EL PASO COUNTY STORMWATER MANAGEMENT PLAN CHECKLIST

Revised 5/21/07

VICINITY MAP

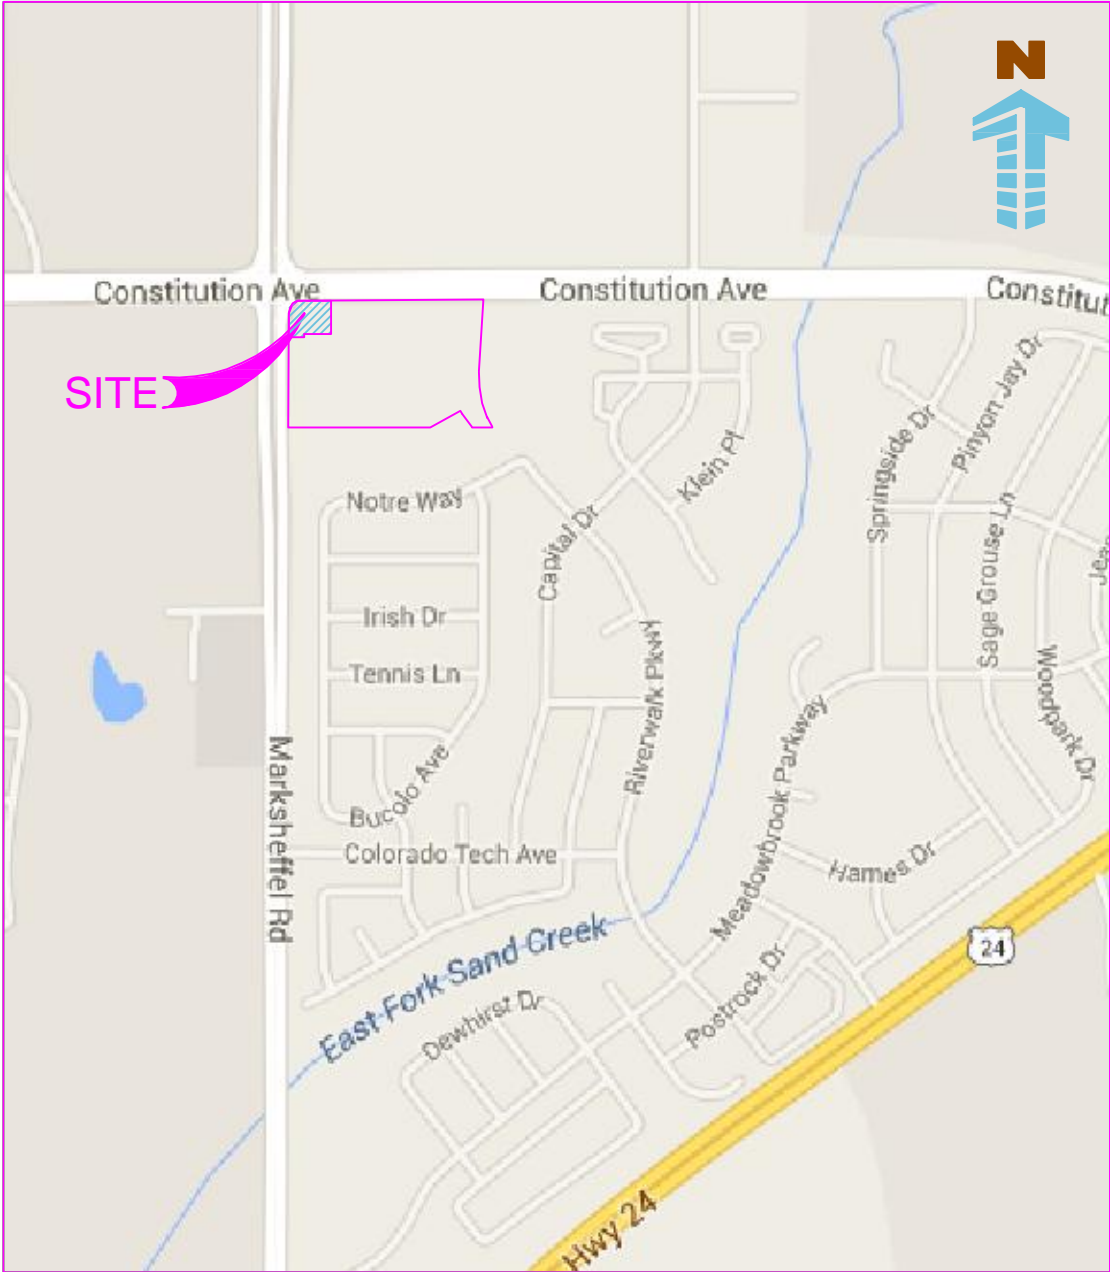
3) Site description and location to include vicinity map (not just Section, Township, Range)

Unresolved
04/24/2018

Include a vicinity map
